May 18, 2022

**Re: Cutters Edge/ Office/ Warehouse**  
**820 Rankin Rd. NE**  
**Traffic Circulation Layout**  
Architect's Stamp 05-03-22 (G15-D049)

Based upon the information provided in your submittal received 05-16-22, the above referenced plan cannot be approved for Building Permit until the following comments are addressed:

FIRE1

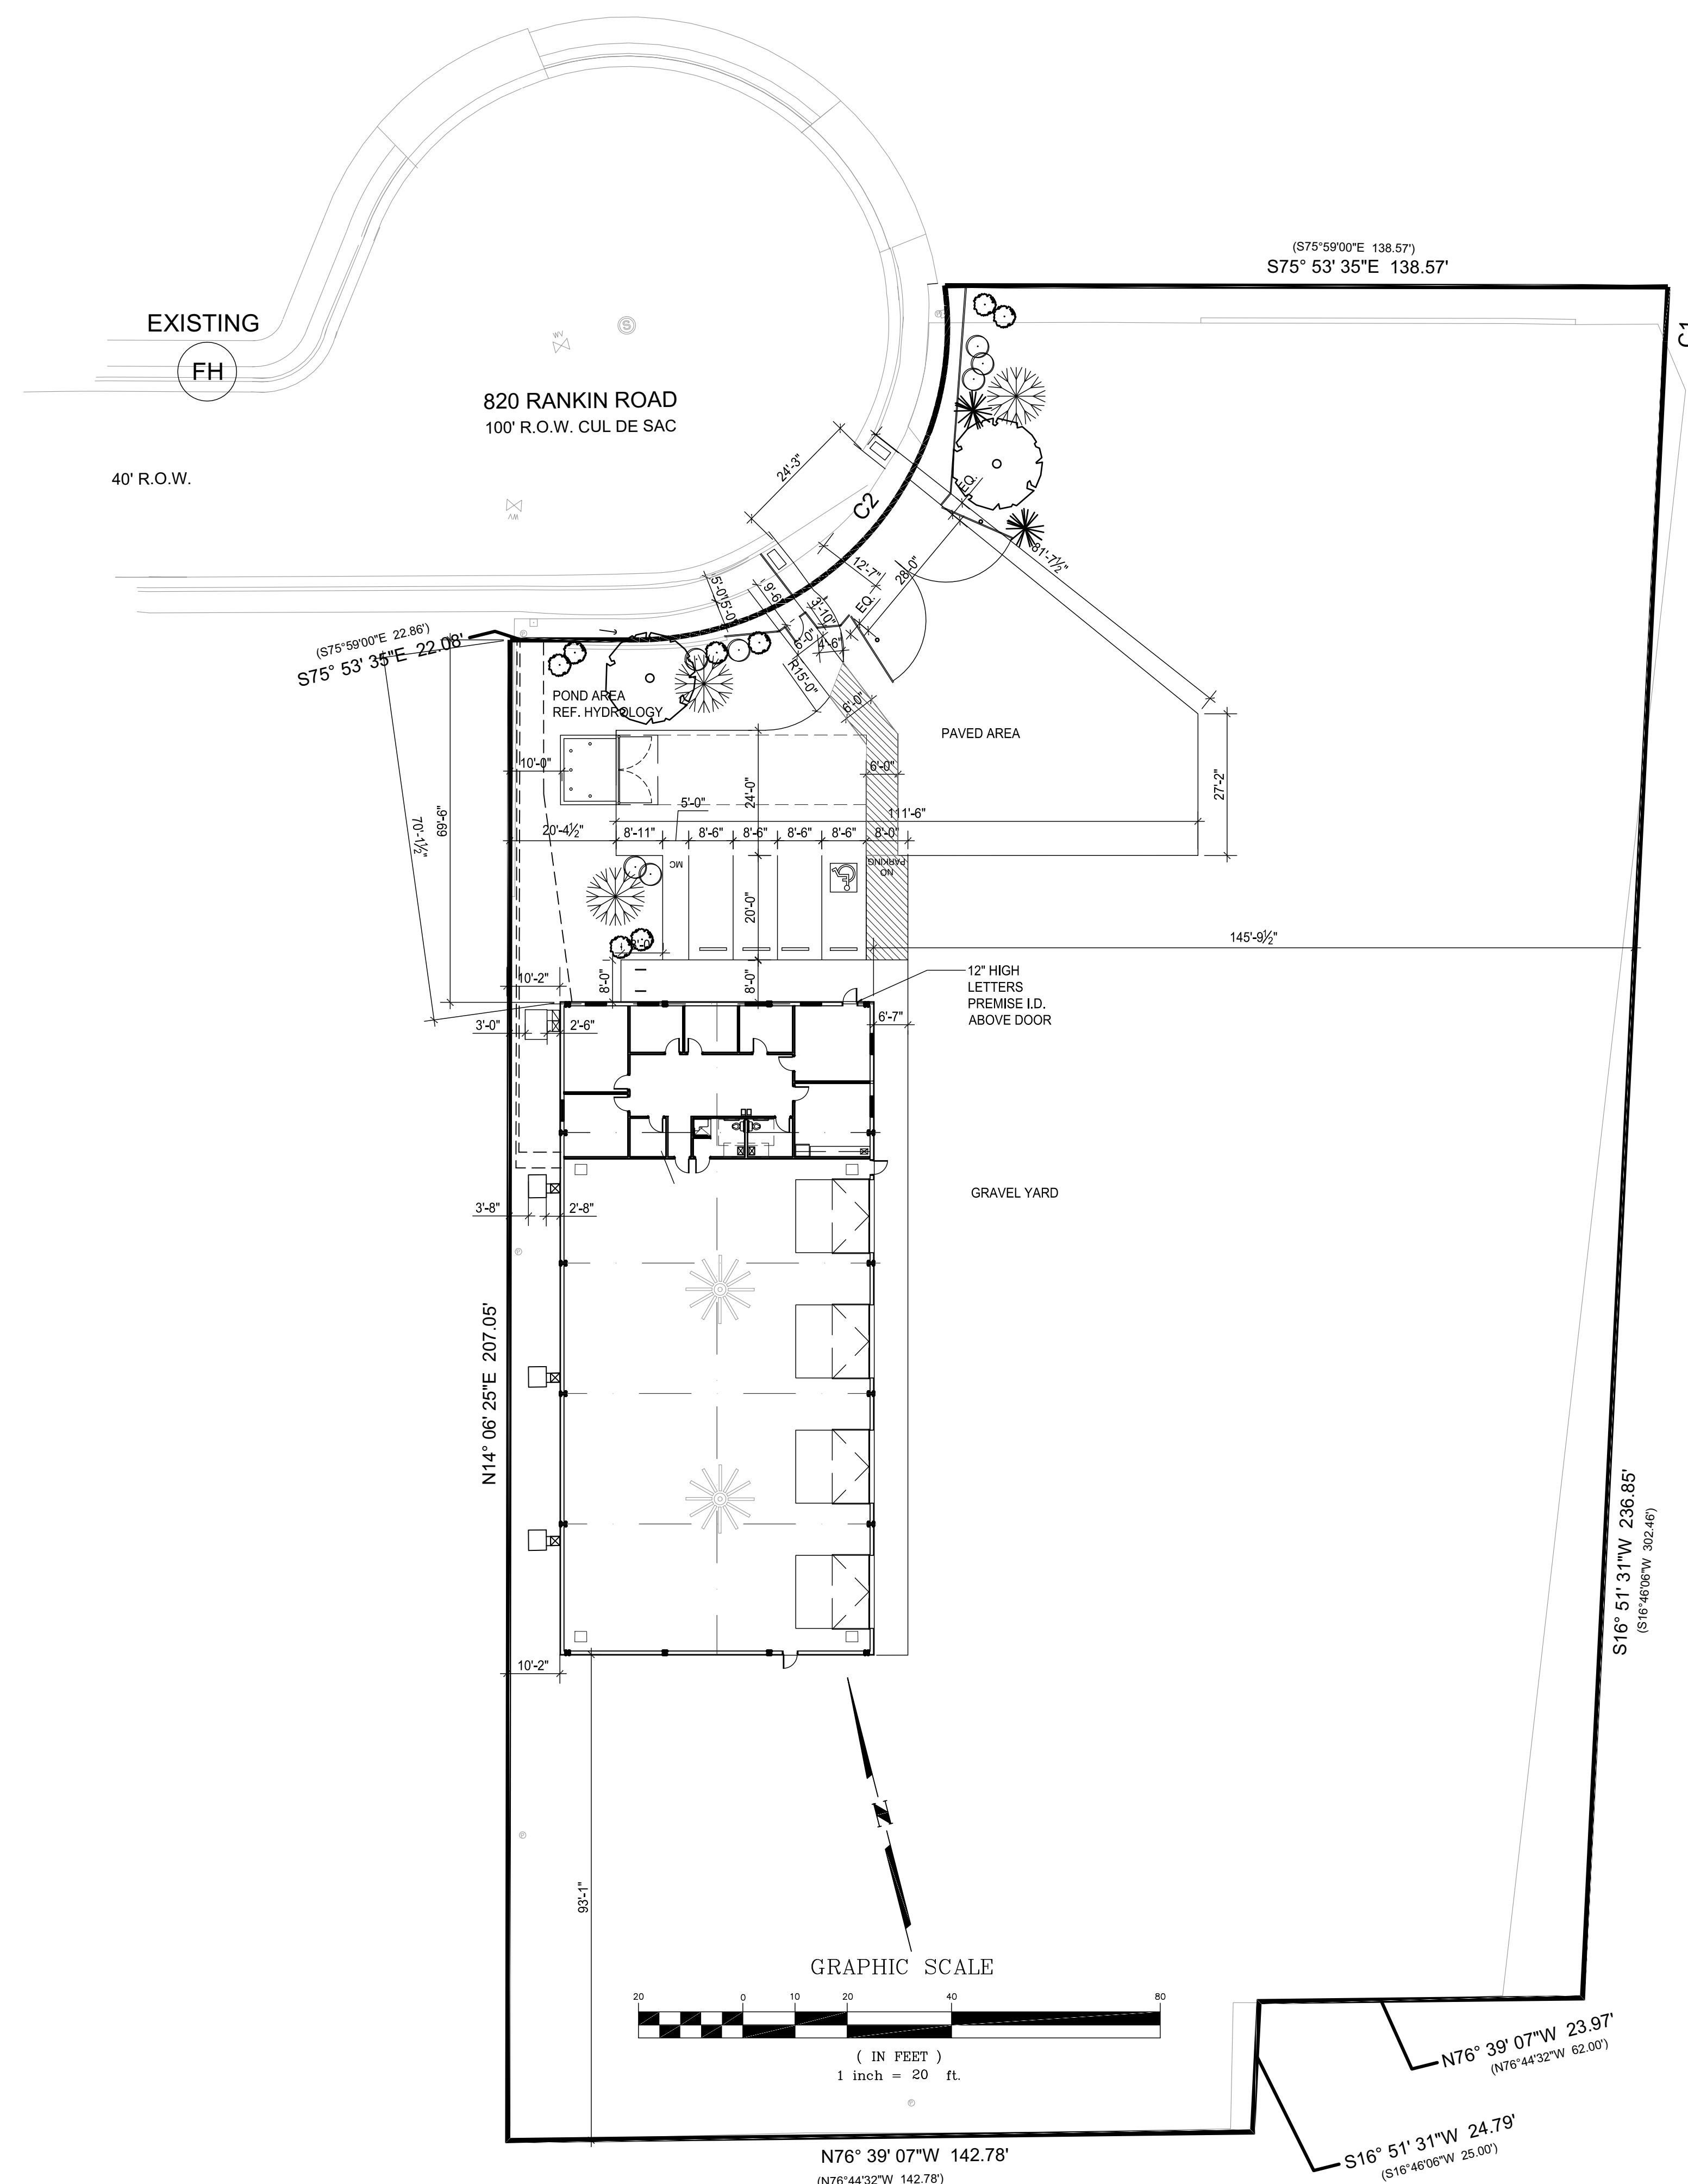
20. Provide a copy of Fire Marshal Approval.
21. Please provide a sight distance exhibit
22. Show the clear sight triangle and add the following note to the plan: "Landscaping and signage will not interfere with clear sight requirements. Therefore, signs, walls, trees, and shrubbery between 3 and 8 feet tall (as measured from the gutter pan) will not be acceptable in the clear sight triangle.

A1.1
TCL

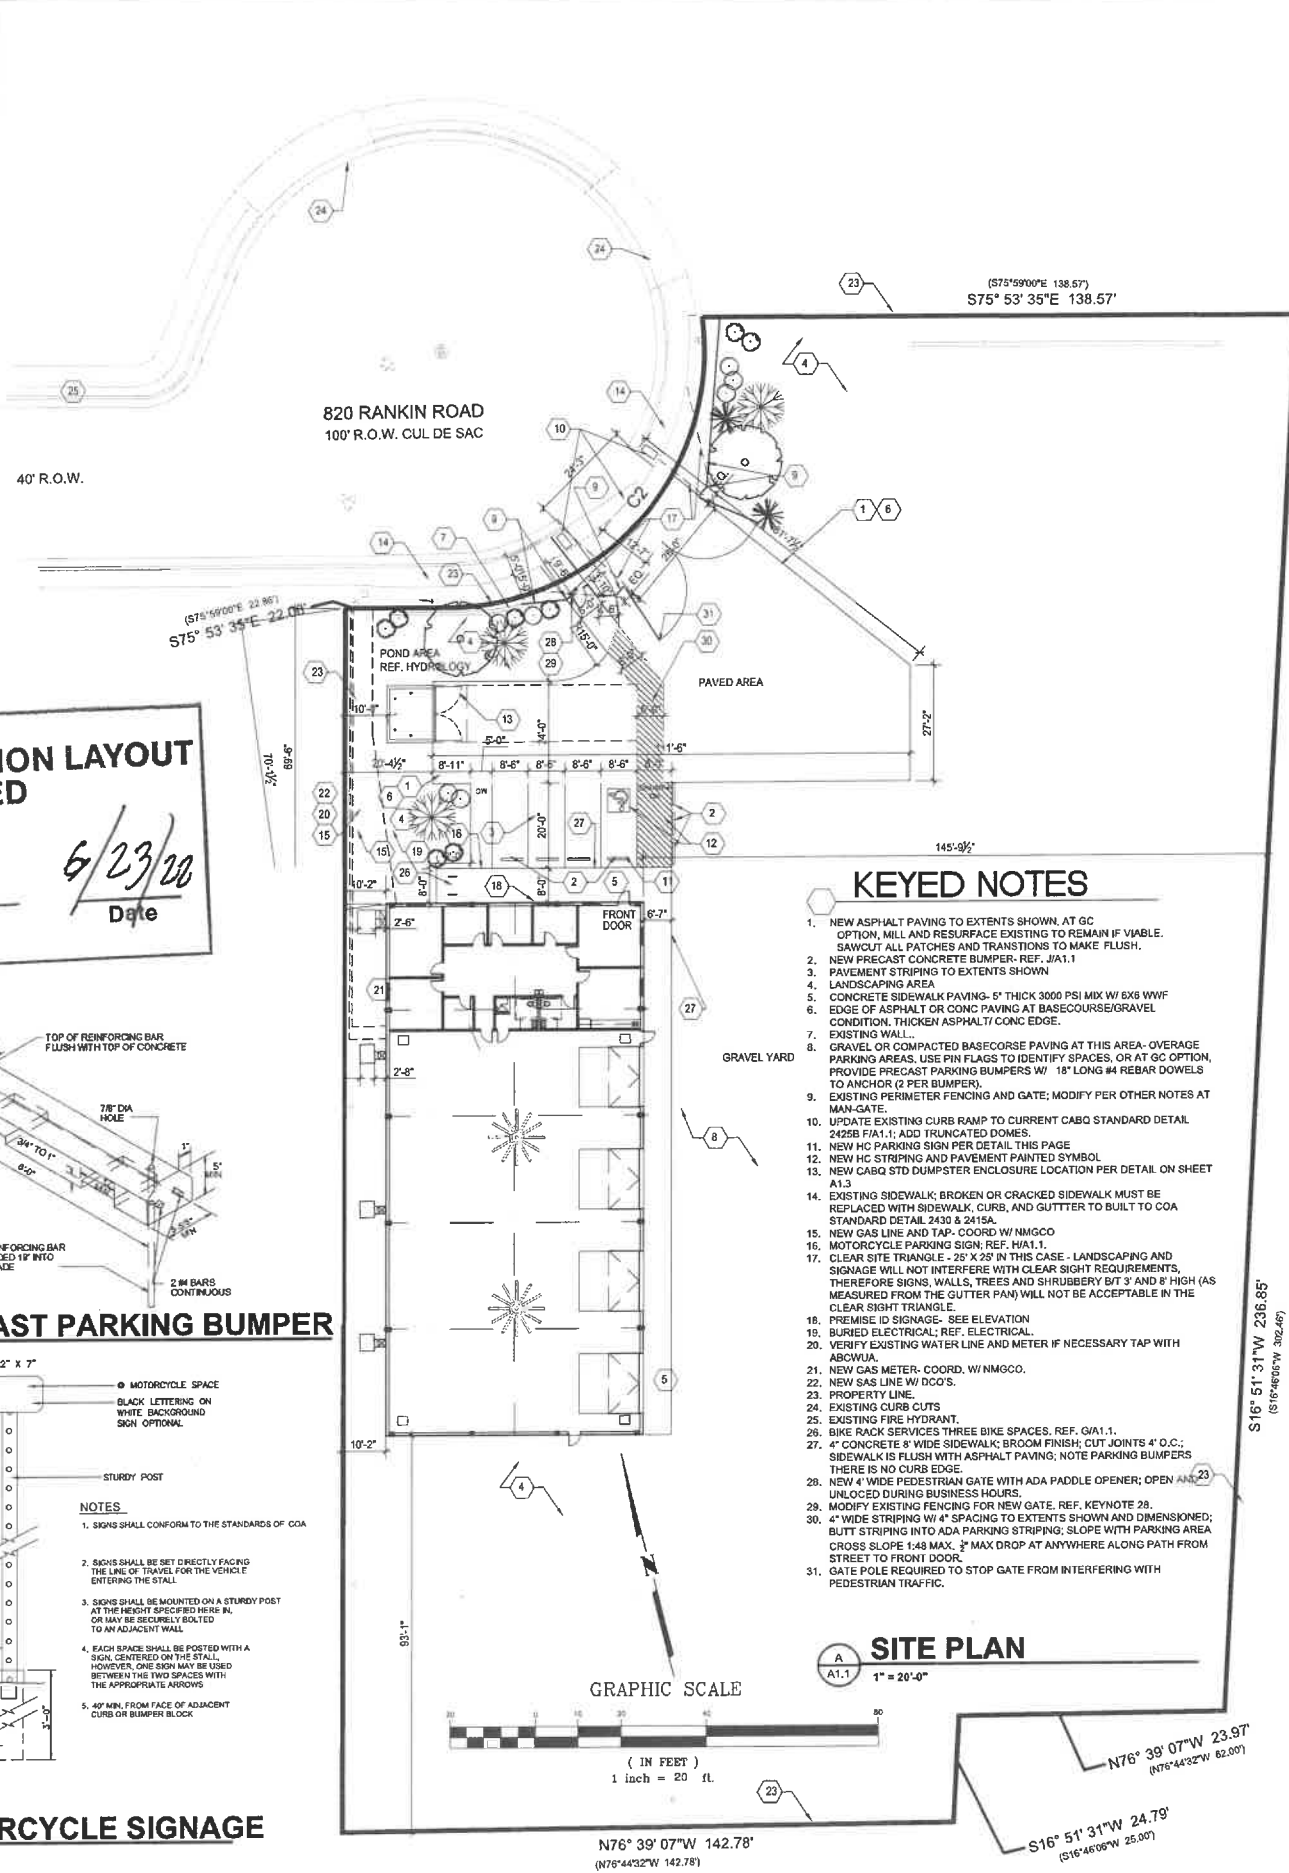
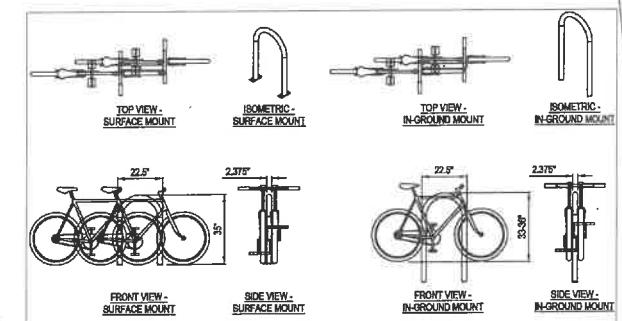
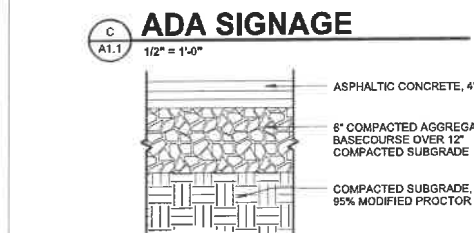
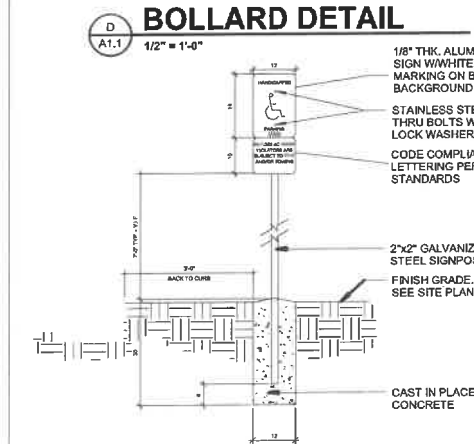
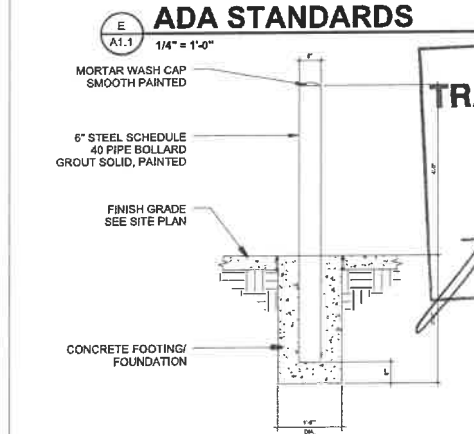
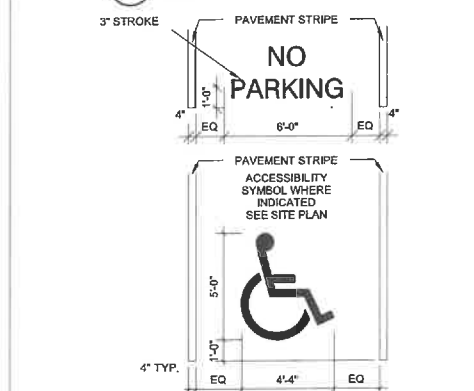
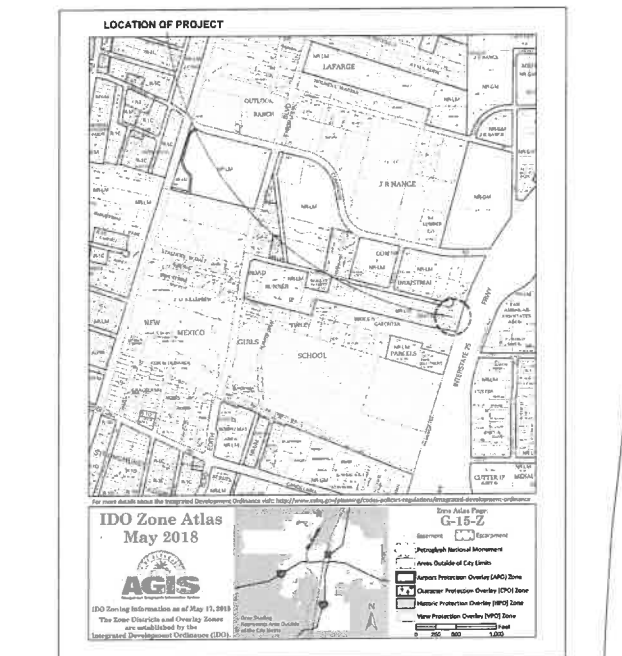
1. List the number of Bicycle and Motorcycle parking spaces required by the IDO.
2. Define the property line.
3. Identify the right of way width, medians, curb cuts, and street widths on Rankin Road

4. Keynote 10: There are three type of COA std dwg. 2425B. Please specify the drivepad you referred to.
5. Provide the dimension from the back of the drivepad to the gate.

6. ADA curb ramps must be updated to current standards and have truncated domes installed.
7. Keynote 12: Provided details for ADA aisle Striping and "NO PARKING" words.

8. Motorcycle parking spaces shall be designated by its own conspicuously posted upright sign, either free-standing or wall mounted per the zoning code.

9. The pavement marking "MC" should be shown in the opposite direction for motorcycles entering the parking space.
10. All bicycle racks shall be designed according to the following guidelines:

- a. The rack shall be a minimum 30 inches tall and 18 inches wide.
  - b. The bicycle frame shall be supported horizontally at two or more places. Comb/toaster racks are not allowed.

- c. The rack shall be designed to support the bicycle in an upright position. See the IDO for additional information.
  - d. The rack allows varying bicycle frame sizes and styles to be attached.

- e. The user is not required to lift the bicycle onto the bicycle rack.
  - f. Each bicycle parking space is accessible without moving another bicycle.

11. Bicycle racks shall be sturdy and anchored to a concrete pad.

12. A 1-foot clear zone around the bicycle parking stall shall be provided.
13. Bicycle parking spaces shall be at least 6 feet long and 2 feet wide.
14. Per the IDO, a 6 ft. wide ADA accessible pedestrian pathway is required from the public sidewalk to the building entrances. Please clearly show this pathway and provide details.

15. Per DPM, a 6 ft. wide ADA accessible pedestrian pathway is required from the ADA parking stall access aisles to the building entrances. Please clearly show this pathway and provide details.

16. ADA accessible pedestrian pathway should not be placed behind parking space or adjacent to a vehicular way. Vehicle and pedestrian/wheel chair conflicts should be avoided as much as possible.

17. Define ADA pedestrian pathway by labeling of ramp, flush pavement, and dimensioning of pathway.
18. Keynote 2: Please call out detail of new precast bumper.

19. Refuse vehicle maneuvering shall be contained on-site. The refuse vehicle shall not back into the public right of way.; provide a copy of refuse approval.

23. Please specify the City Standard Drawing Number when applicable.
24. Please provide a letter of response for all comments given.
